Cabarita Mixed Use Development-6 (MP07_0179-Mod-6)
Request for Response to Submissions

ATTACHMENT 1

DEPARTMENT OF PLANNING, INDUSTRY AND ENVIRONMENT

SECTIONS

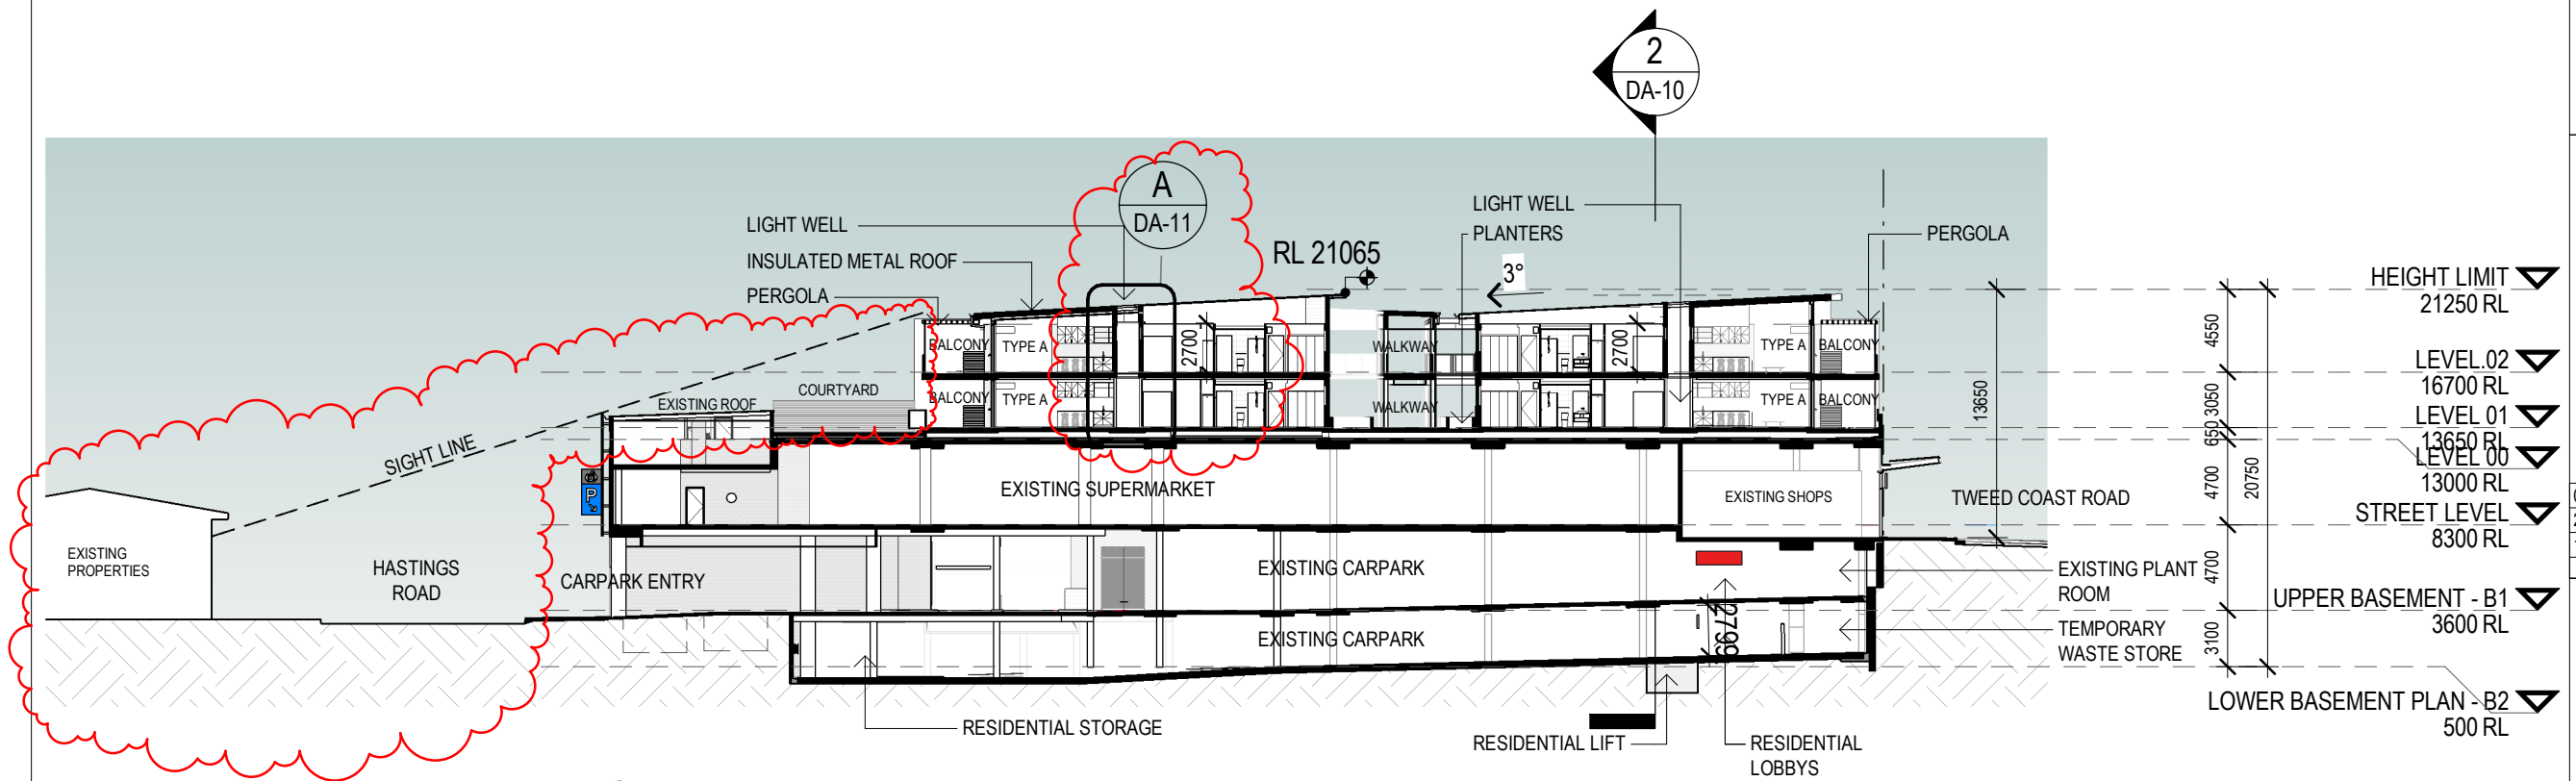
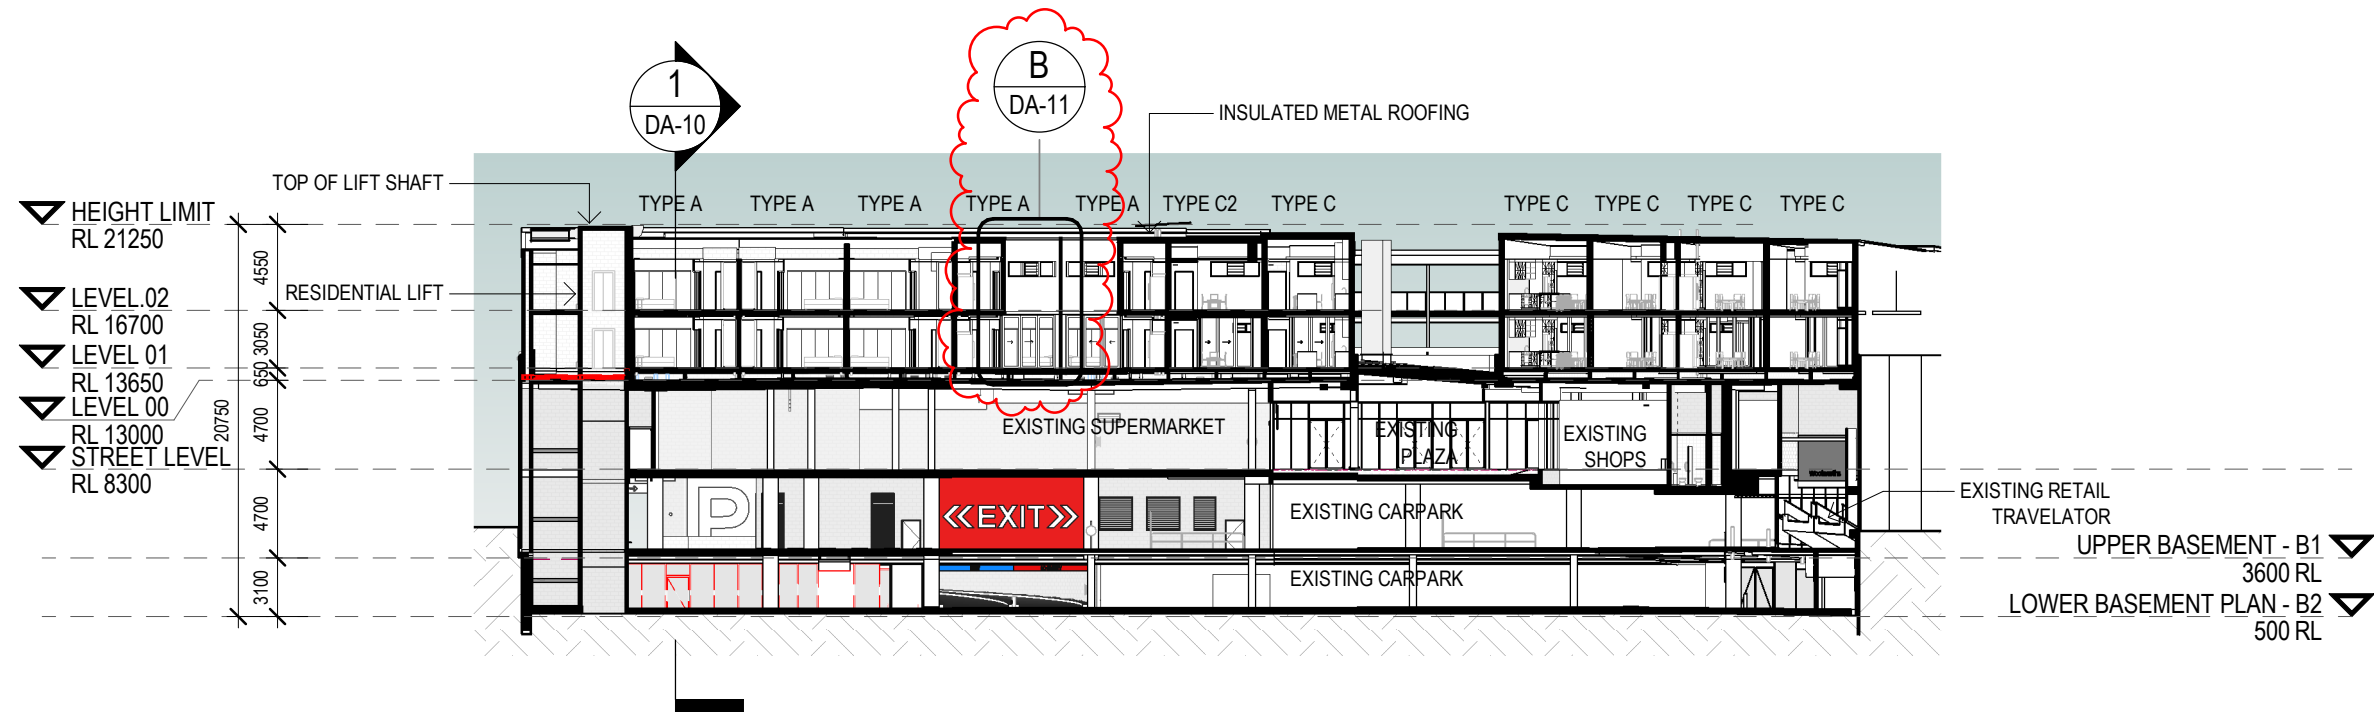
- Please clearly indicate the floor ceiling heights for the units located on Level 2. The approved plans indicate these units achieve a floor to ceiling height of 2.7m, consistent with SEPP 65, the then relevant Residential Flat Design Code and current Apartment Design Guide. The proposed modification appears to reduce the floor to ceiling for Level 2 to 2.55m or less. Given that the depth and narrow width of the units limit opportunities for penetration of solar access, a minimum of 2.7m floor to ceiling height should be maintained.

drawing title
TYPICAL LIGHTWELL SECTIONS

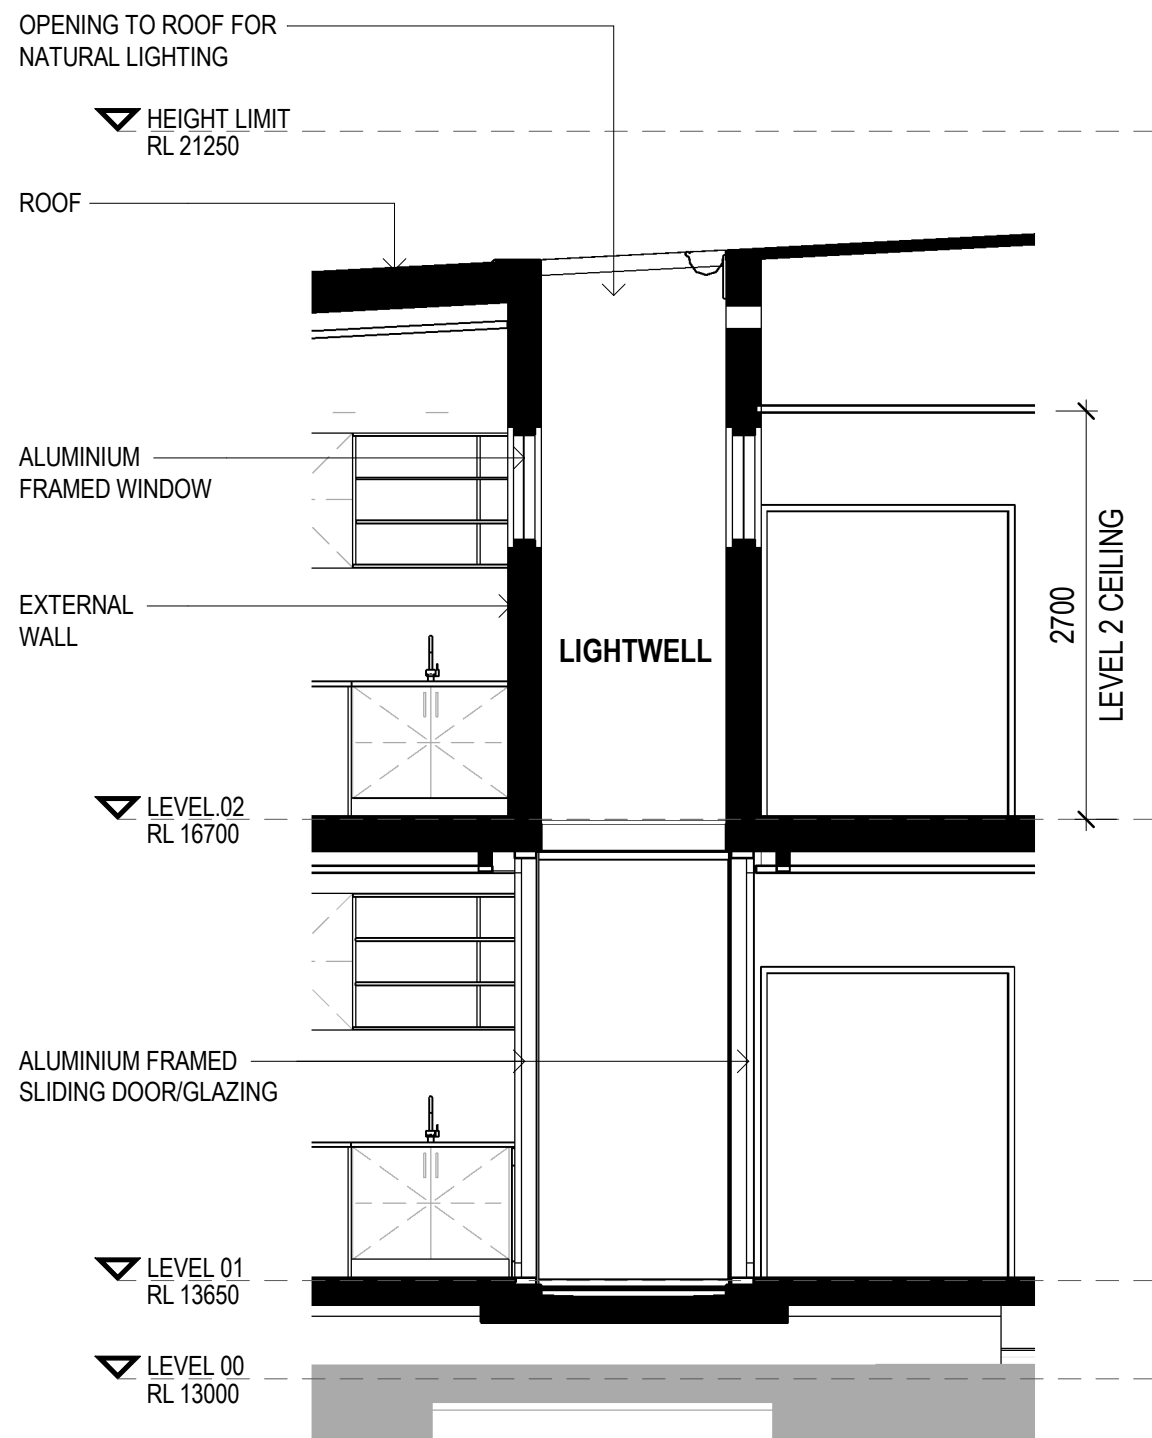
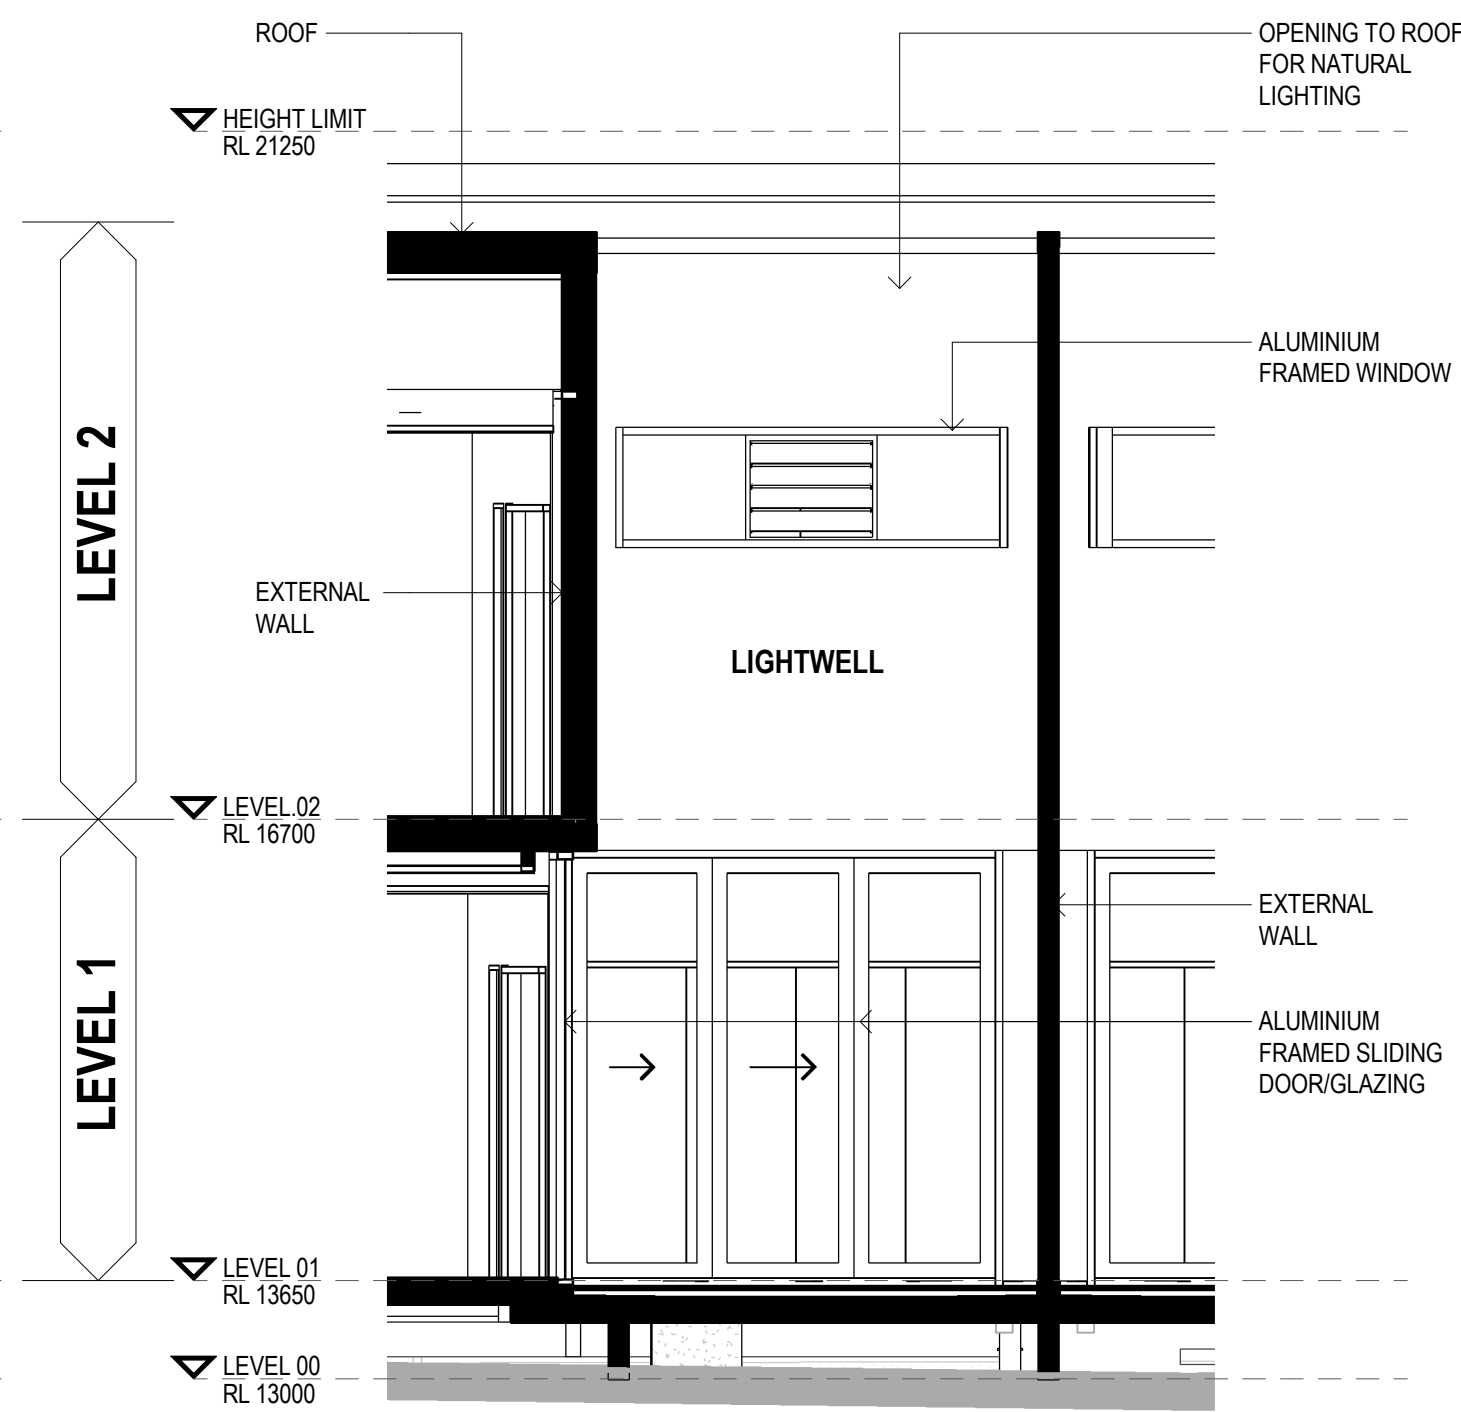
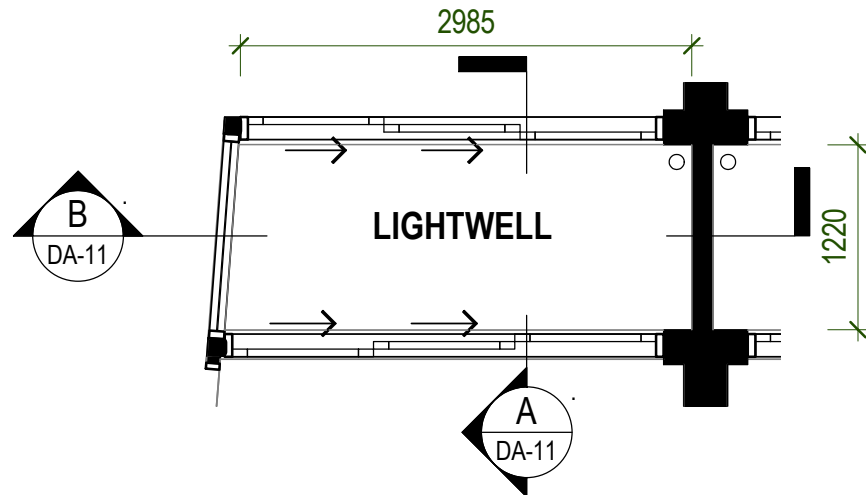
- Please provide further information regarding the proposed lightwells including a section figure to understand how they function.
- Please address whether the lightwells on Level 2 will be openable to residents and how/if they provide light to Level 1 units.
